WATERBURY SANITARY FORCE MAIN
UTILITY CONSTRUCTION SET
LEGEND SHEET

WATERBURY SANITARY FORCE MAIN
 UTILITY CONSTRUCTION SET
 SANITARY FORCE MAIN PLAN & PROFILE

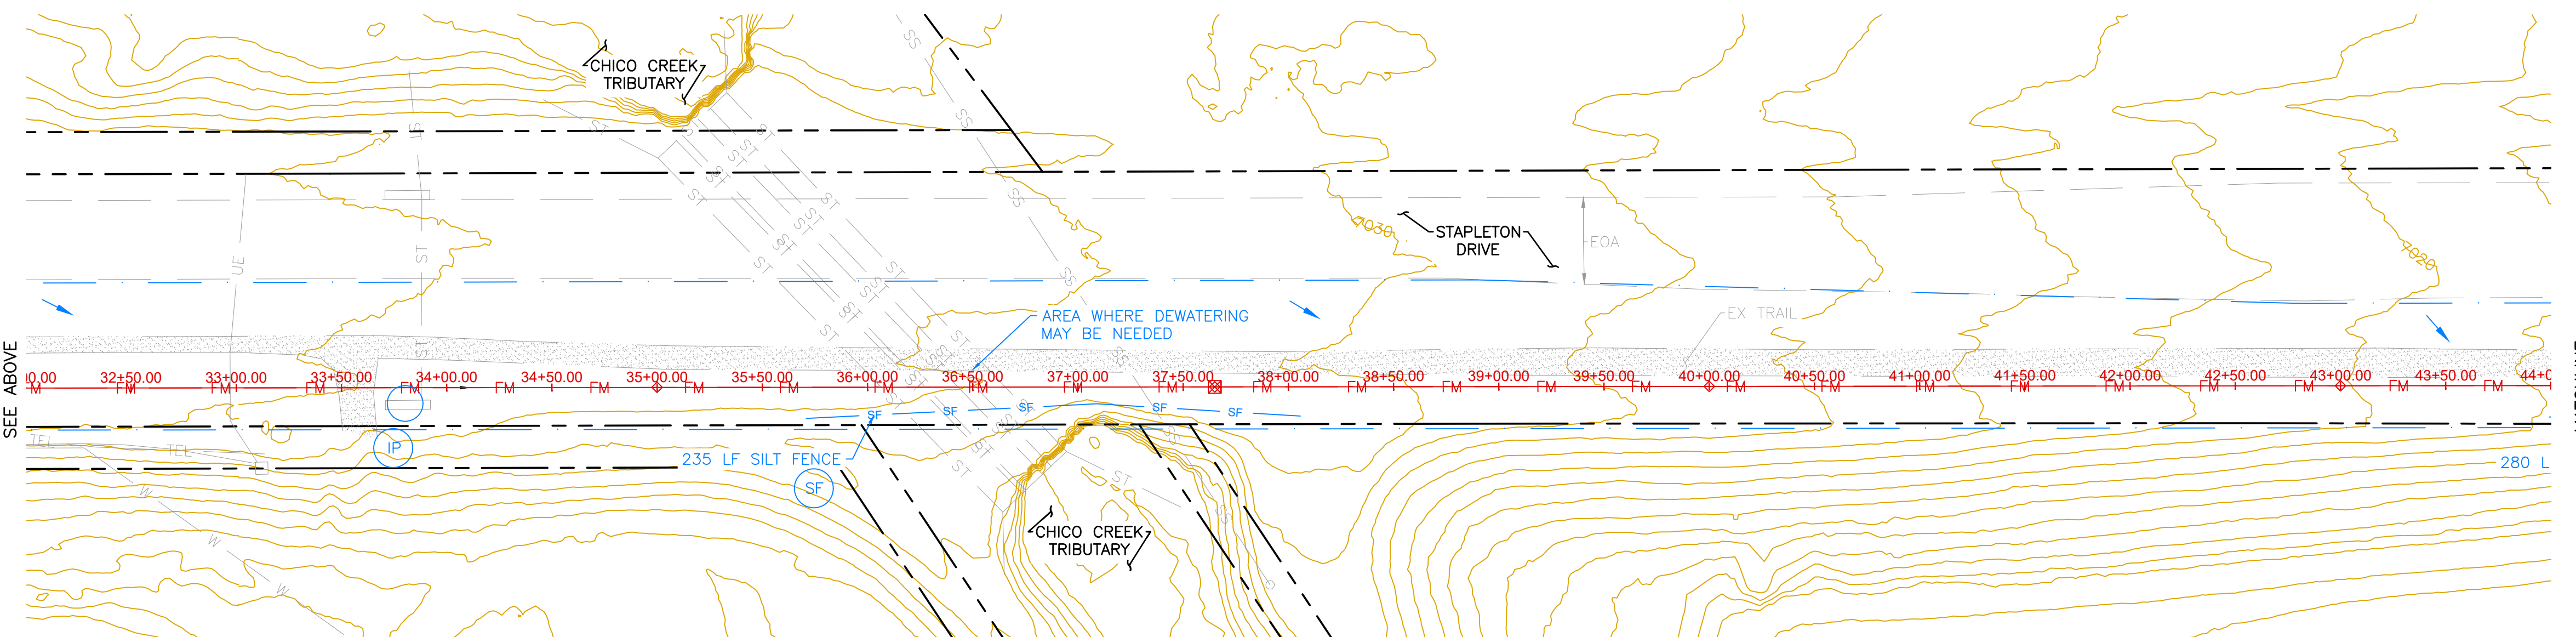
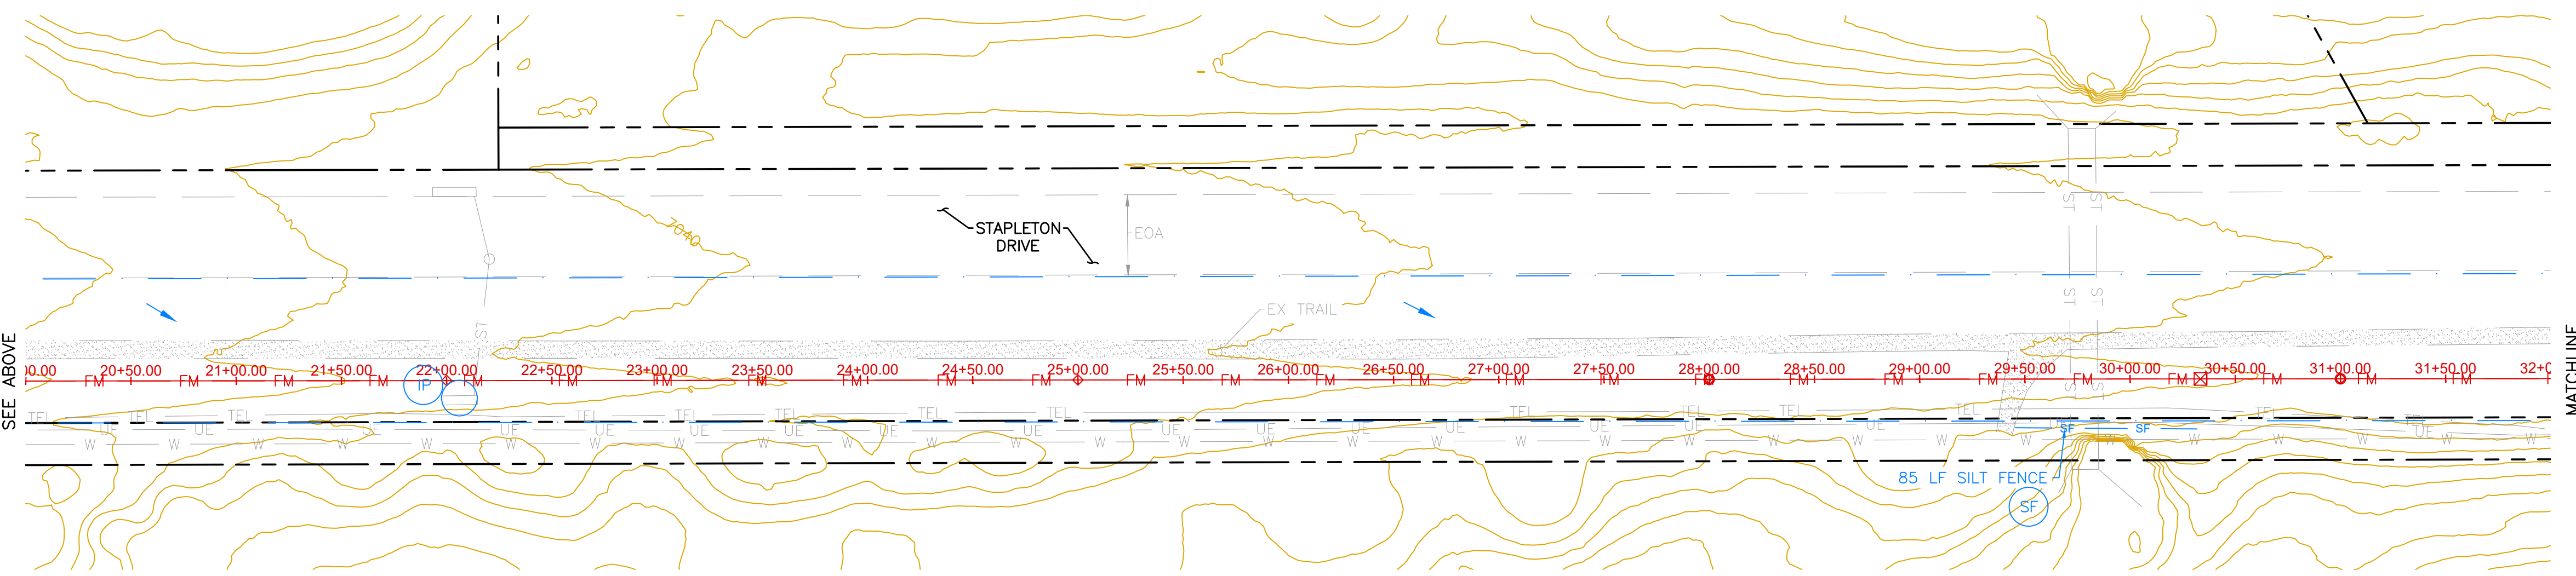
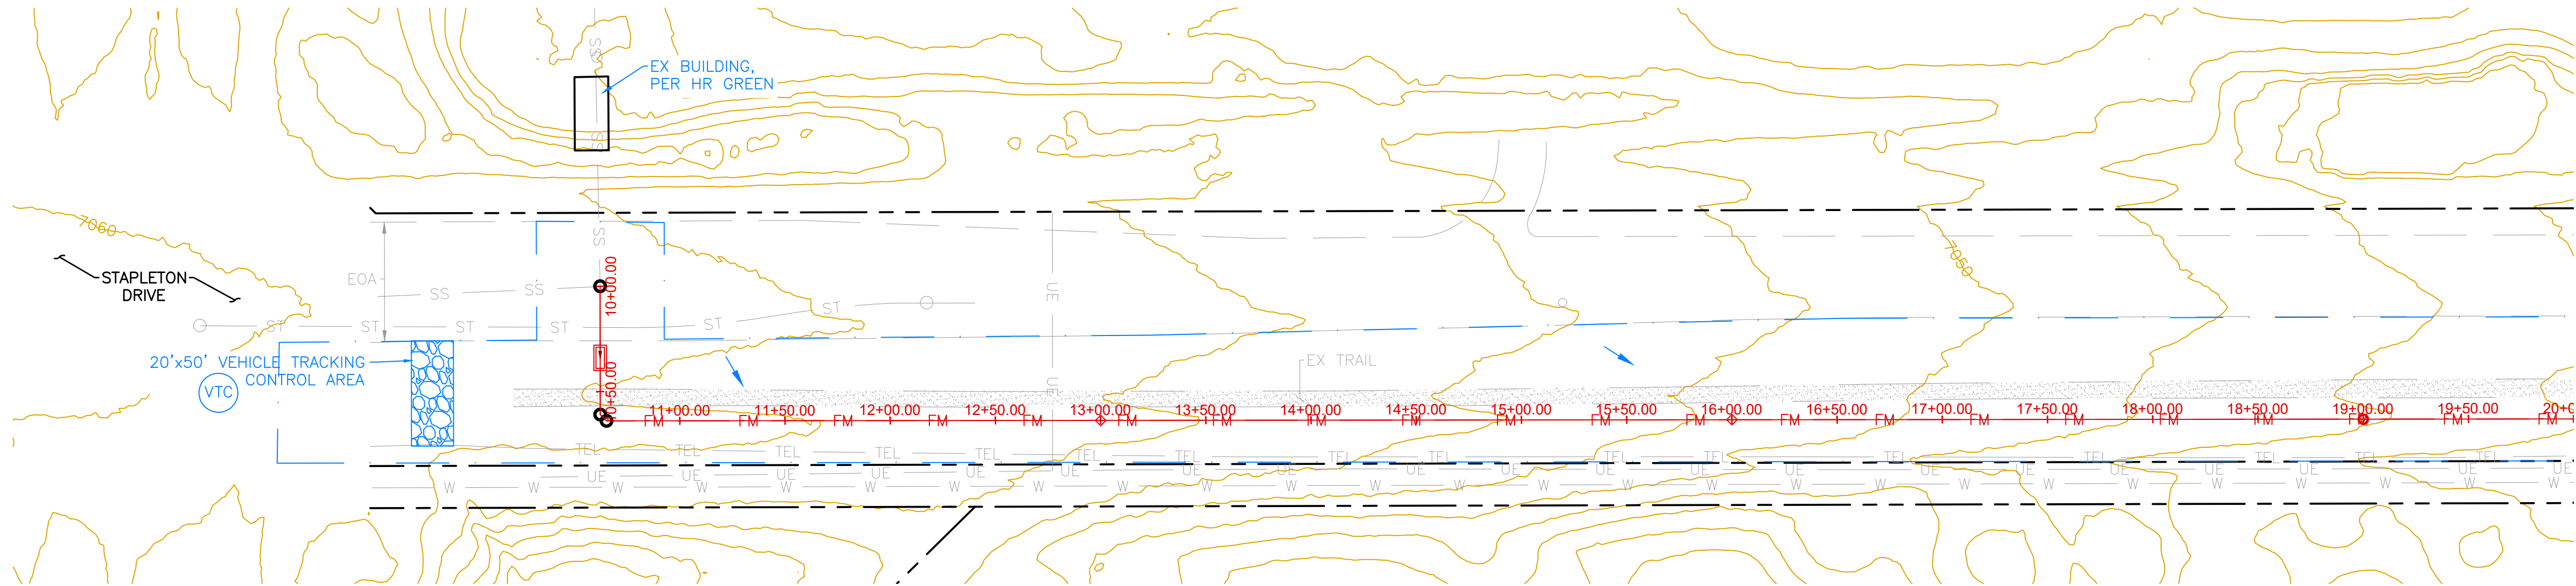
Unresolved - dotsaleh
Define paved streets and streets (crossings or parallel streets) on all sheets (a gray shaded symbol would work).

Typical comment: Define New Asphalt for Proposed Street and show and label them on the plan layouts to all applicable sheets.

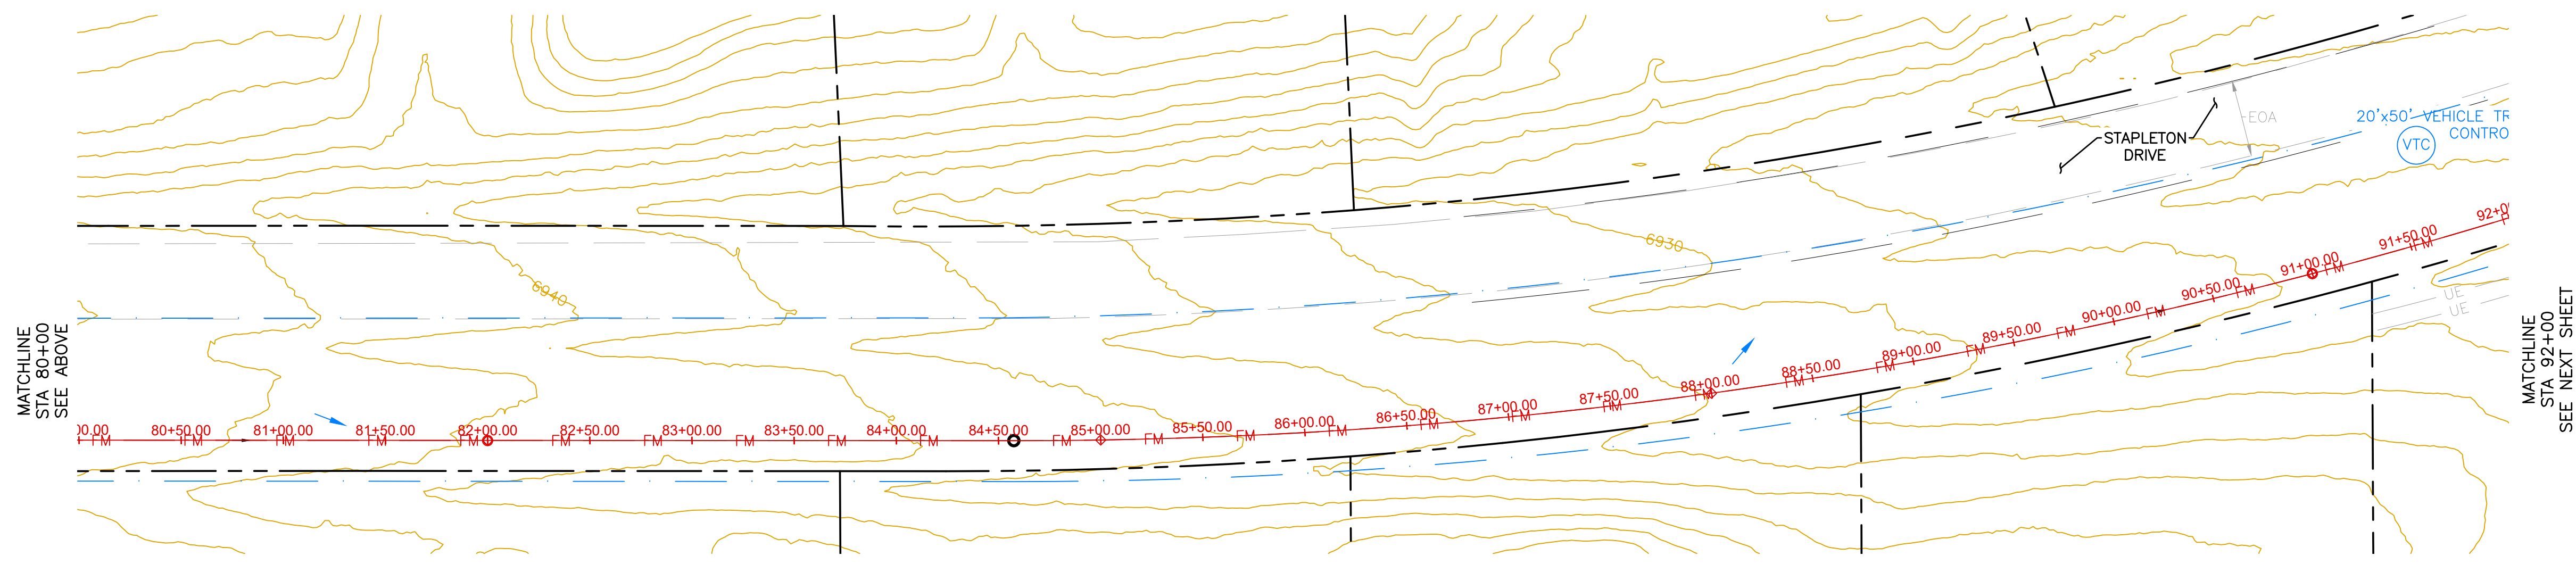
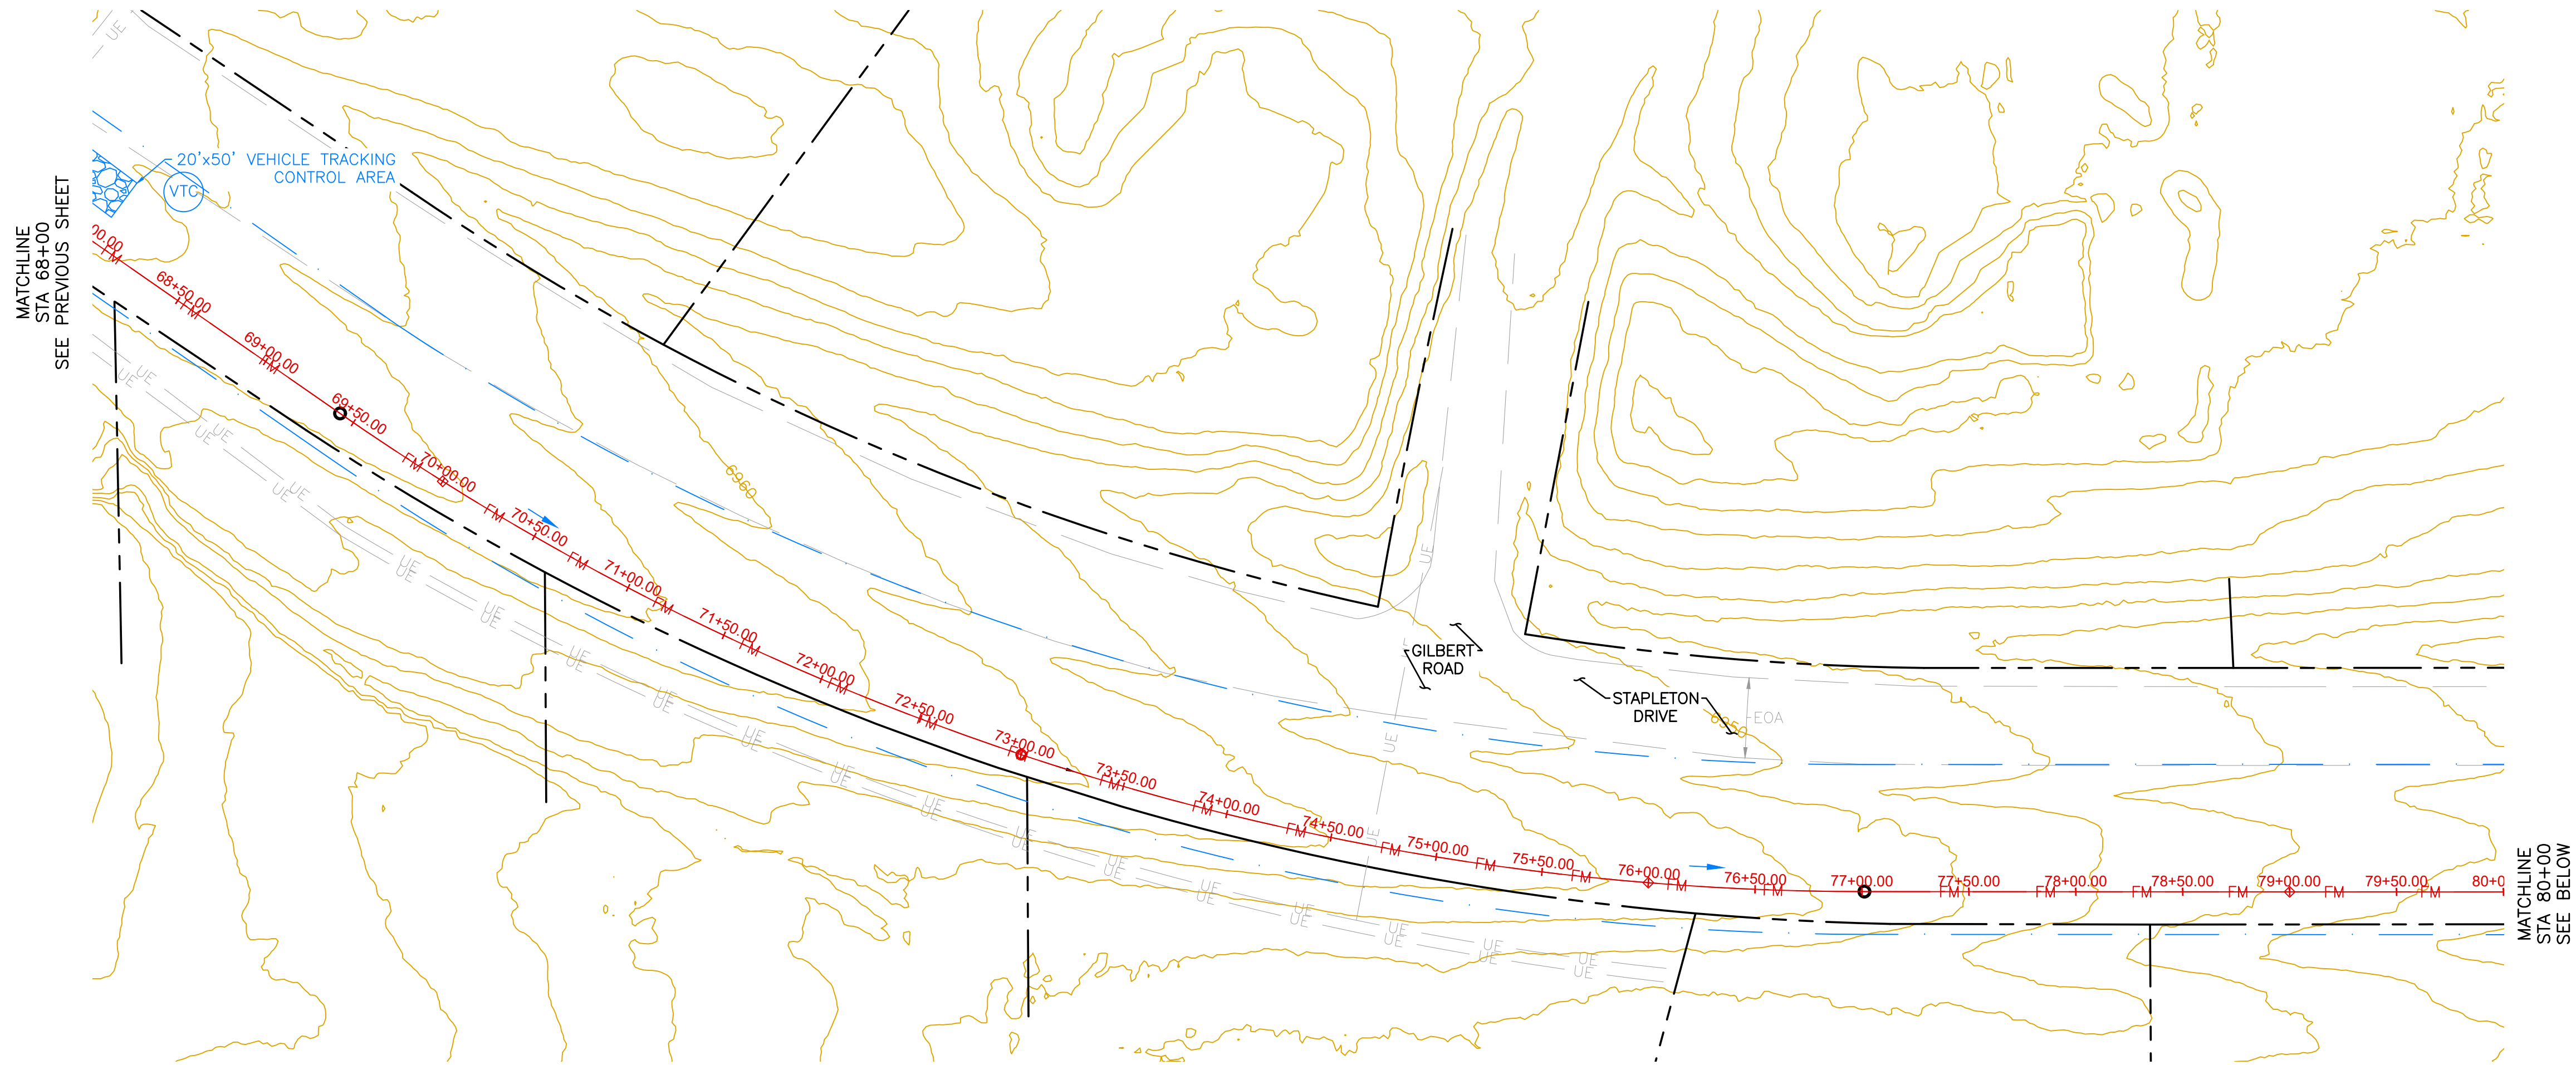
Typical comment: Indicate the following for each parcel abutting the proposed FM: Parcel number, parcel address and owner name.

Typical comment: Indicate the following for each parcel abutting the proposed FM: Parcel number, parcel address and owner name.

I added this to the overview sheet.

I added this to the overview sheet.
